Item No. Report of the Interim Director of Planning, Regeneration & Public Realm**Address** 4 CHURCH CLOSE WEST DRAYTON**Development:** Conversion of existing 6 people Class C4 HMO to a 7 people Sui Generis HMO**LBH Ref Nos:** 27891/APP/2022/2859

A non-determination appeal has been lodged in relation to this application which seeks planning permission to convert an existing 6 person Class C4 HMO to a 7 person Sui Generis HMO.

EXISTING PARKING
RETAINED

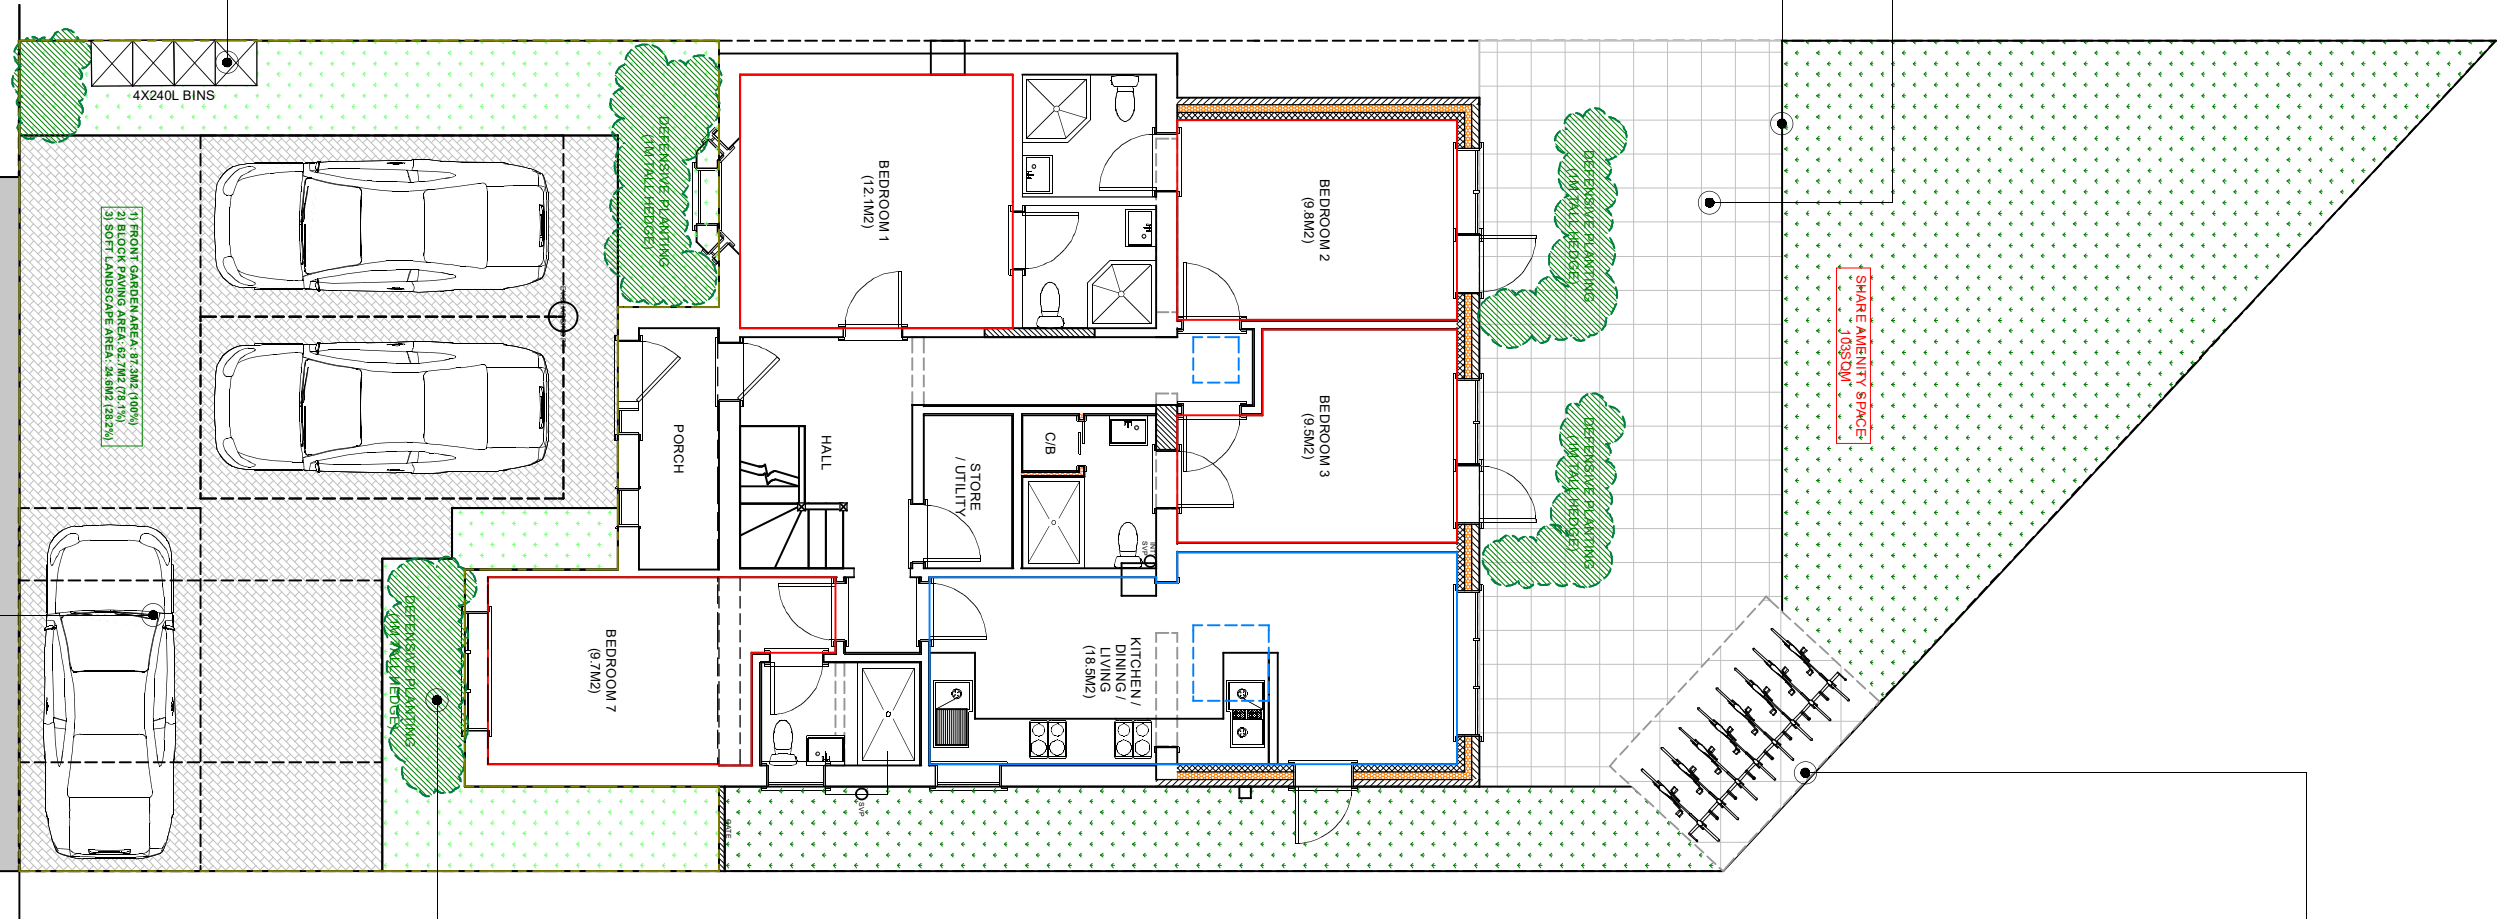
The Highway Authority does not consider the proposed layout of the 3no. car parking spaces to be satisfactory. Two spaces would be perpendicular to the highway and the third parallel. This layout makes it difficult to manoeuvre in and out of the parallel parking space, particularly when the two perpendicular spaces are occupied. As a result some drivers may resort to parking on-street which would impede the free flow of traffic and increase the road safety risk.

The development would provide 2no. usable car parking spaces, which it is anticipated would result in 2no. vehicles being displaced on-street. Given that Church Close has capacity to accommodate just 3no. cars on-street, situations could arise such as cars parked blocking driveways, cars being parked on both sides of the road opposite one another, as Church Close is narrow and this would restrict the free flow of traffic especially for larger vehicles such as refuse vehicles. It is also anticipated that drivers may also resort to using the car park serving the The Closes park, taking away parking for whom it is provided.

3 parking spaces are proposed for future residents. Two of the car parking spaces would be perpendicular to the highway, the third parallel. As mentioned by the Borough's Highways Officer, 4 parking spaces are required for the proposed development. 3 Parking spaces are proposed, meaning that inadequate parking would be provided for the new HMO.

Furthermore, the parking space proposed parallel to the road is not considered to be fit for purpose due to its orientation and relationship to the dropped kerb and site access. The space would be difficult to enter and exit safely and without excessive maneuvers. This could lead to any potential occupier of the space parking at the roadside. Taking into consideration these points, it is considered that 2 functional parking spaces would be provided for the proposed development. As such, there would be a shortfall of 2 parking spaces at the site. The shortfall would lead to additional roadside parking (in an area with existing roadside parking issues) and congestion, which would create a more hazardous environment for pedestrians and road users. The proposed development is therefore considered to be contrary to Policies DMT 1, DMT 2 and DMT 6 of the Hillingdon Local Plan: Part 2 (2020), Policy T4 of the London Plan (2021), and paragraph 111 of the NPPF (2021).

Hillingdon is not a wheelie bin borough, therefore our collection vehicles cannot lift 240L containers. Our crews also cannot empty these by hand as they are very deep and it is a Health and Safety issue. I would recommend providing 80L containers or a bulk waste container to site to accommodate for the waste generated here. If the bulk container option is considered, we encourage refuse and recycling to be introduced and a 1100L container for each would be sufficient. Can you also advise how the bins will be presented for collection? Will there be provisions in the house and communal areas to recycle?

Concerns were raised by the Borough's Waste Management Officer regarding the size of the proposed waste storage facilities. Had the application been recommended for approval, a condition would have been recommended, requiring full details of the design, location and sizes of all refuse and recycling storage facilities to be used at the new HMO. The applicant would be required to provide waste storage of an appropriate size.

Had the application been recommended for approval, a condition would have been recommended, requiring full details of the design, location and sizes of all refuse and recycling storage facilities to be used at the development. All other issues have been addressed in the main body of the report.
